RE: Objection to Planning Application ref: A/68/15/PDH at 24 Lucksfield Way, Angmering

I am contacting you with regard to the proposed rear extension under Planning Application ref: A/68/15/PDH at 24 Lucksfield Way, Angmering and wish to advise you that I strongly object to the planning application submitted, as an adjoining property owner.

DRG No  
1509/C02

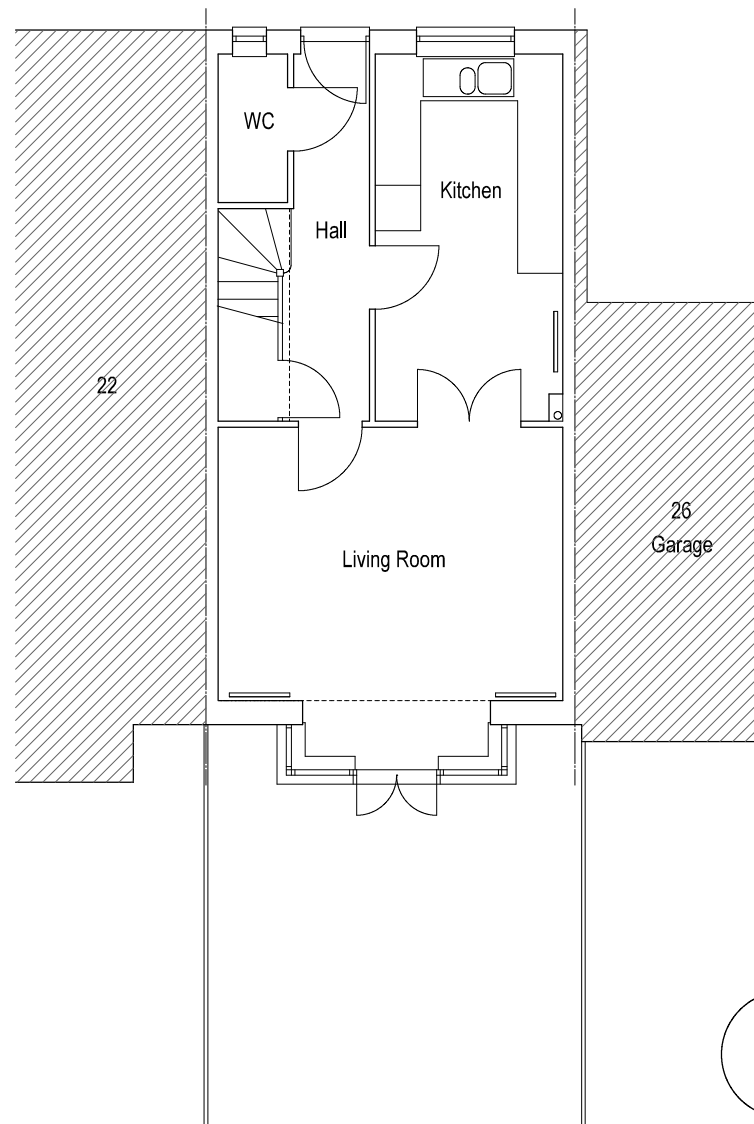
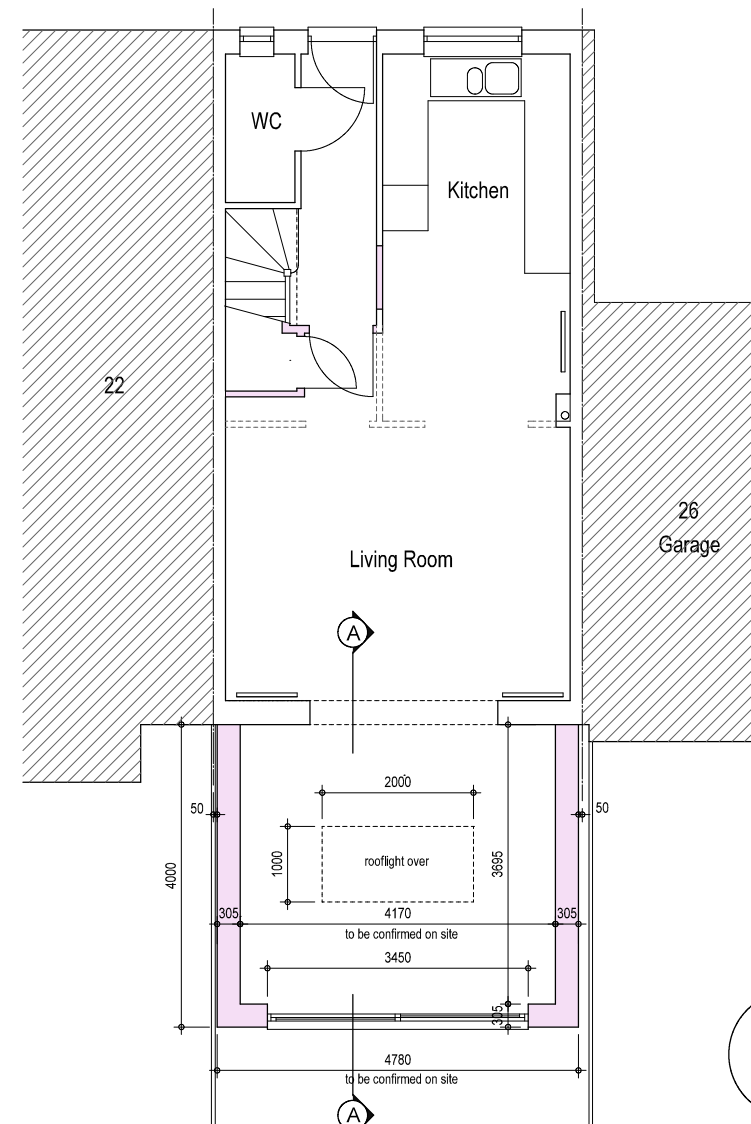
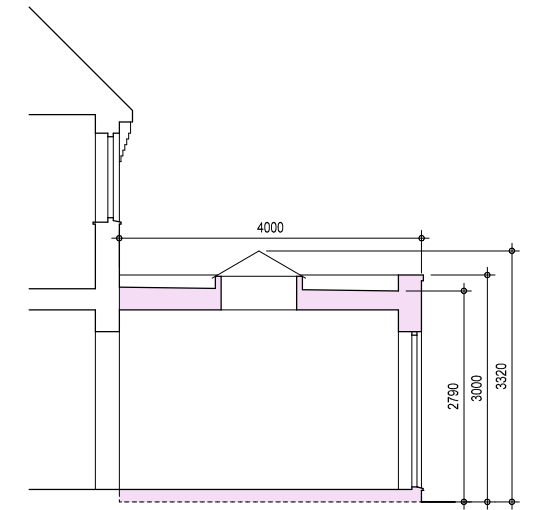
- 1) The proposed rear extension is for a flat roofed brick structure of height 3 metres (with further height added by a glass structure on this roof) and length 4 metres. This harsh 'box' design is not in keeping with other residential and non-residential buildings in both Lucksfield Way and the Bramley Green residential area. Our existing garage blocks/car barns even have pitched roofs with grey or pink tiles (as per the original development) to reflect the same character and build-style as the houses.

- 2) This solid harsh brick design will have maximum negative impact on me as an adjoining property, far greater than a glass conservatory type structure as it will cast shade and block the sunlight that I receive on this side of my garden.

- 7) The design of my house (number 22) and the planning applicants' (number 24), already provides a living room space of 4405mm in length. The proposed length of this extension will be almost that again at 4000mm which means that the proposed extension is large in scale.
- 8) The architects plan shows a space of 50mm behind both side boundaries between my adjoining property 22 Lucksfield Way and the other adjoining property 26 Lucksfield Way. The proposed specifications of build I understand are to have the guttering downpipe on the applicants' boundary, on the side of 26 Lucksfield Way. However, our current downpipe is at least 60mm in width which would not fit in this 50mm gap shown on the plan. **Please also refer to point 15 below concerning 50mm gap.**

- 15) The submitted Architects plan shows that the proposed extension will be located 50mm away from the boundary between my property 22 Lucksfield Way and 24 Lucksfield Way (applicant) and the same distance between the applicant and the other adjoining property 26 Lucksfield Way, on the other side. In my opinion, this is not a sufficient gap and would not allow the applicant to have space to maintain the exterior walls should remedial work be necessary in the future. I would imagine that there should be at least 450mm between their extension exterior wall and each boundary to ensure easy access for a person to walk freely along their proposed extension walls. If this gap is not provided the applicants may need access to my property again in the future and there will be a further impact on myself. If not for maintenance, this space would be needed to avoid there being a 'gathering' of vegetation, debris and leaves (behind the two side extension walls) that cannot be attended to with such an insignificant gap of 50mm.

- Harshness of the building material proposed – a 3 metre high brick wall adjacent to my boundary and my bay window (part of the existing house design), at a proposed length of 4 metres in my garden that is already surrounded by existing brick structures.
